Parish Office: C/o Aldingbourne Community Sports Centre, Olivers Meadow, Westergate, PO20 3YA

Mr S Davis
Principle Planning Officer
Directorate of Place
Arun District Council
Civic Centre
Maltravers Road
Littlehampton
West Sussex BN17 5LF

20 January 2022

Thank you for advising us that the Application Ref. AL/113/21/OUT for Land at Bayards, Level Mare Lane, Eastergate will be heard at your planning meeting on 2 February 2022, we have just received notification of the date (21st January 2022) but would like to submit the following information.

Figure No. 01 - Bat Activity Survey
Land at Fontwell Avenue, Fontwell, Eastergate, West Sussex

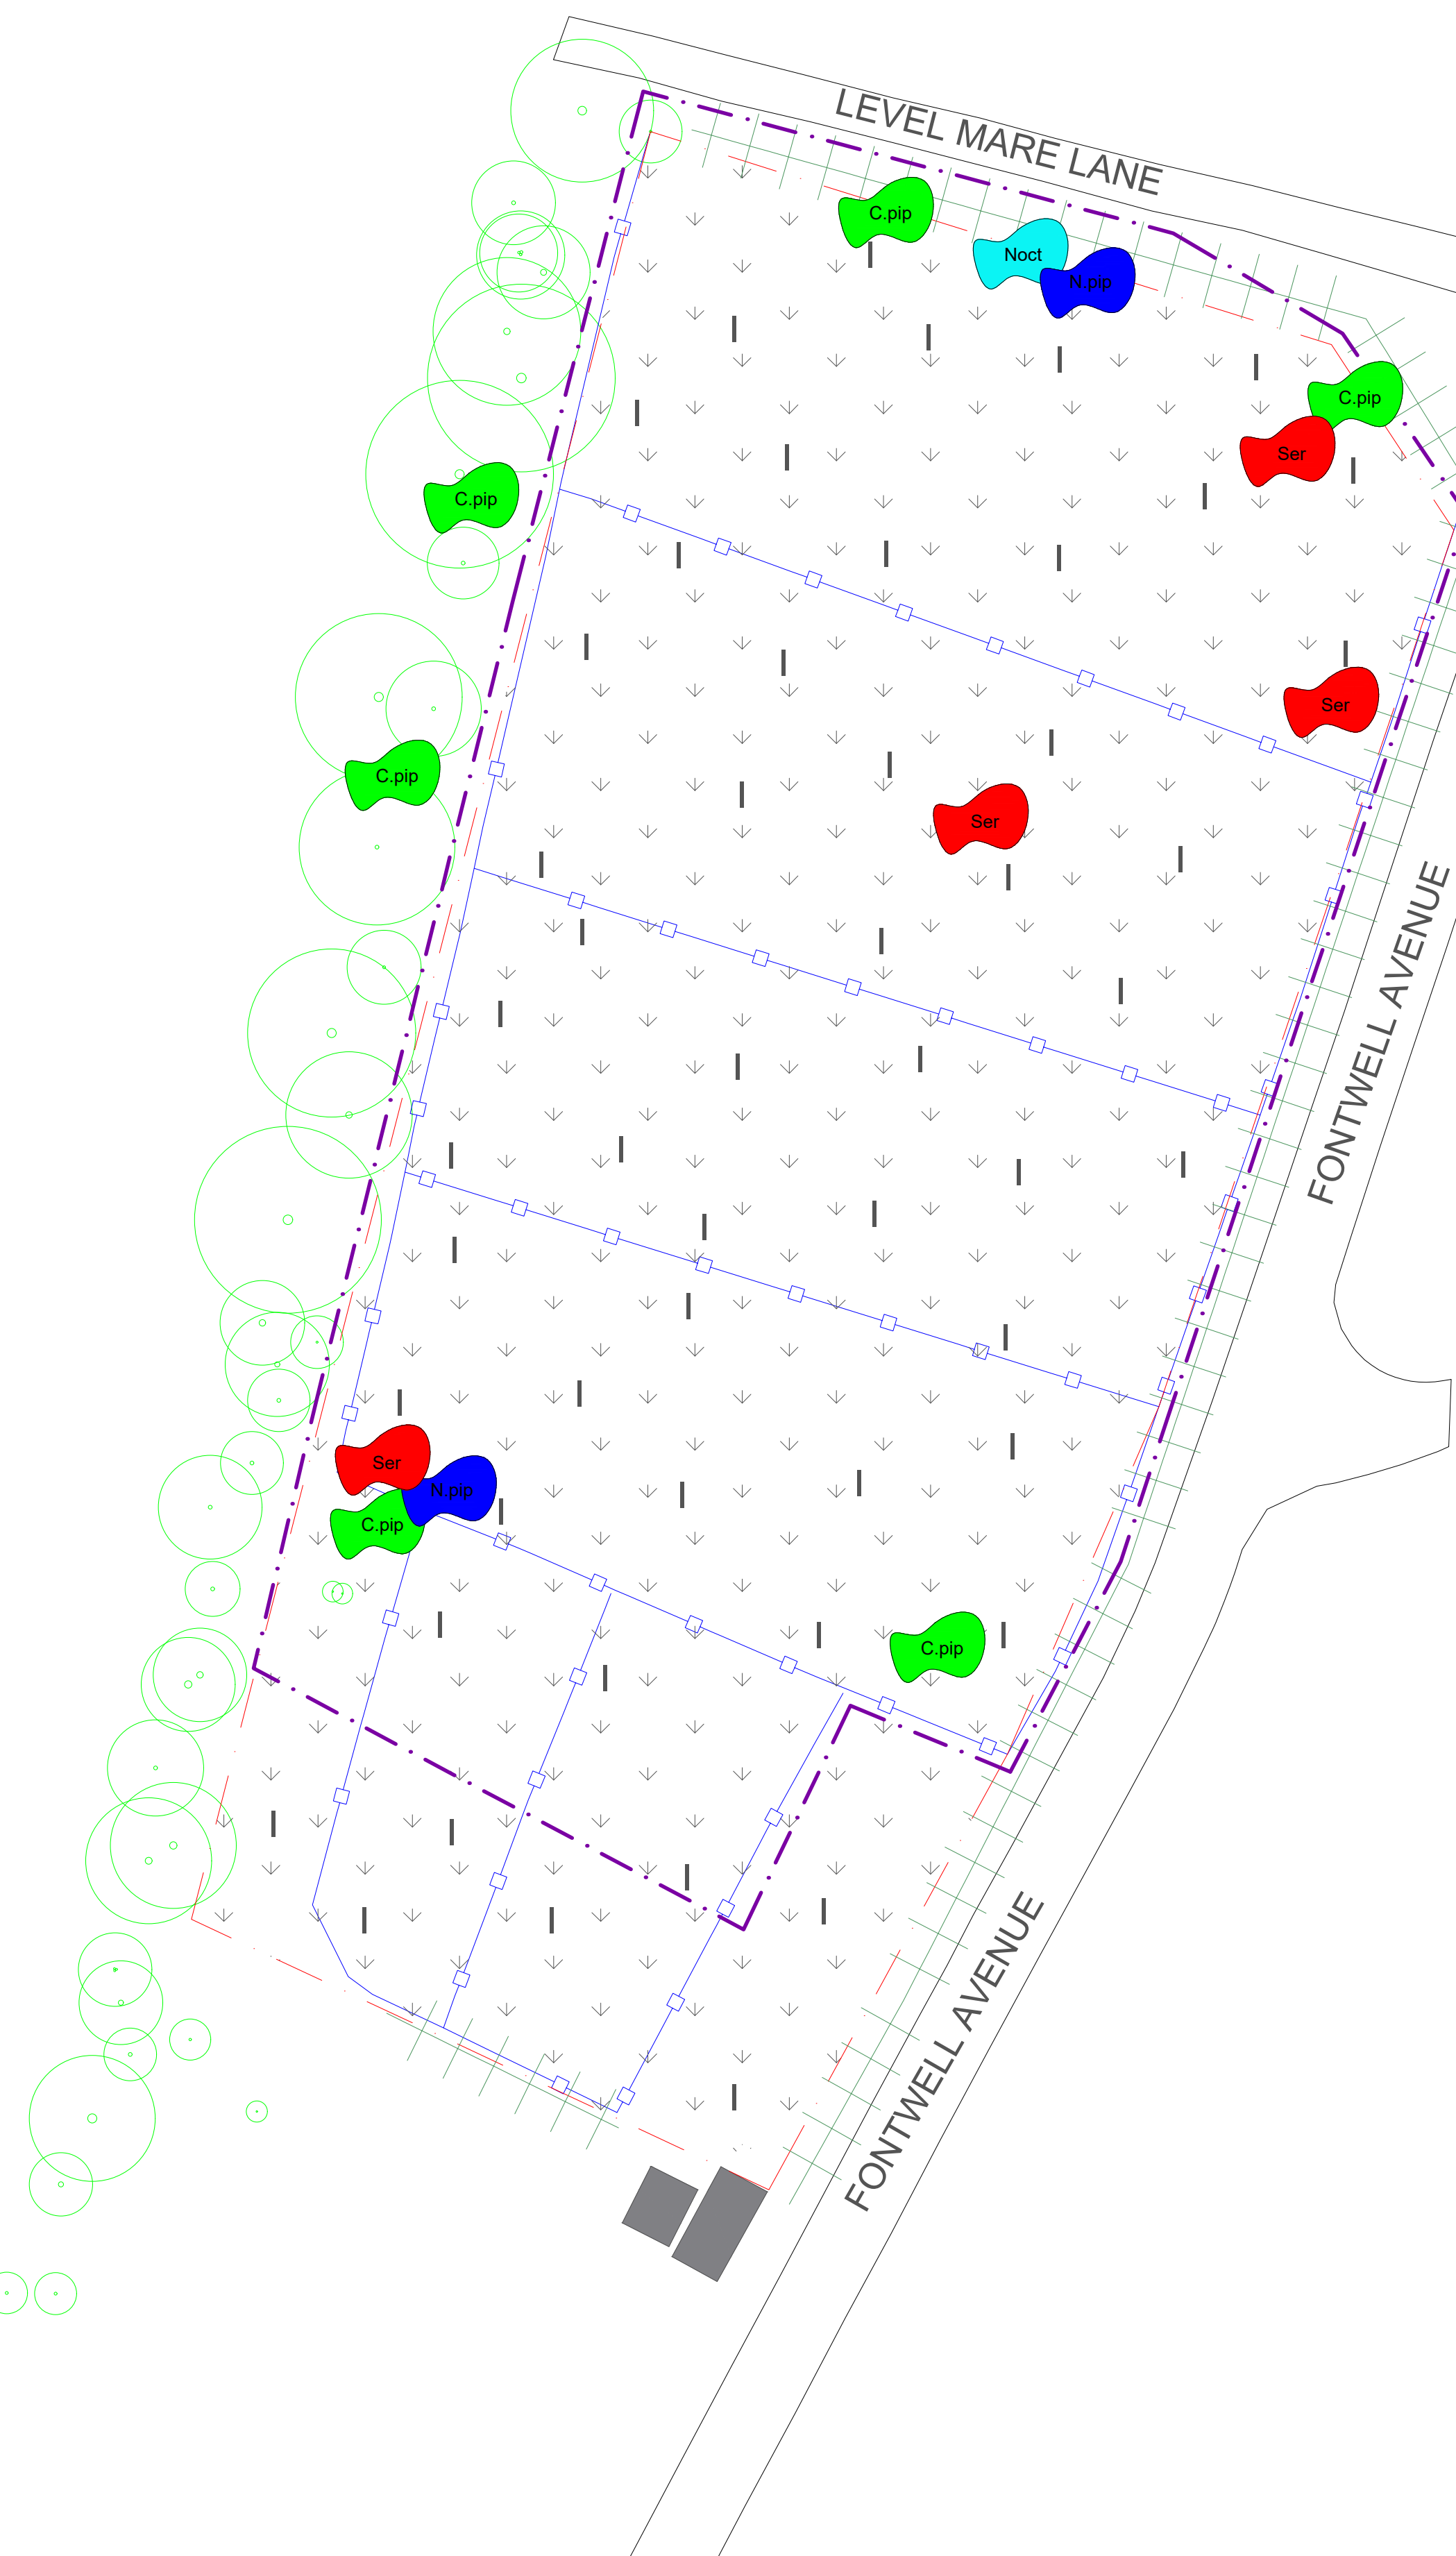
The Bat Report mentions static bat monitor recordings made at the site for 28 nights during 2020. Section 3.1.6 refers the reader to 3 deployment location for these, which it states are plotted on “Figure 01.” However, the deployment locations of the static bat monitor do not appear on Figure 001. Data was recorded for *Myotis* species of bat during static and transect surveys at the site, which also appears to have been omitted from Figure 001.
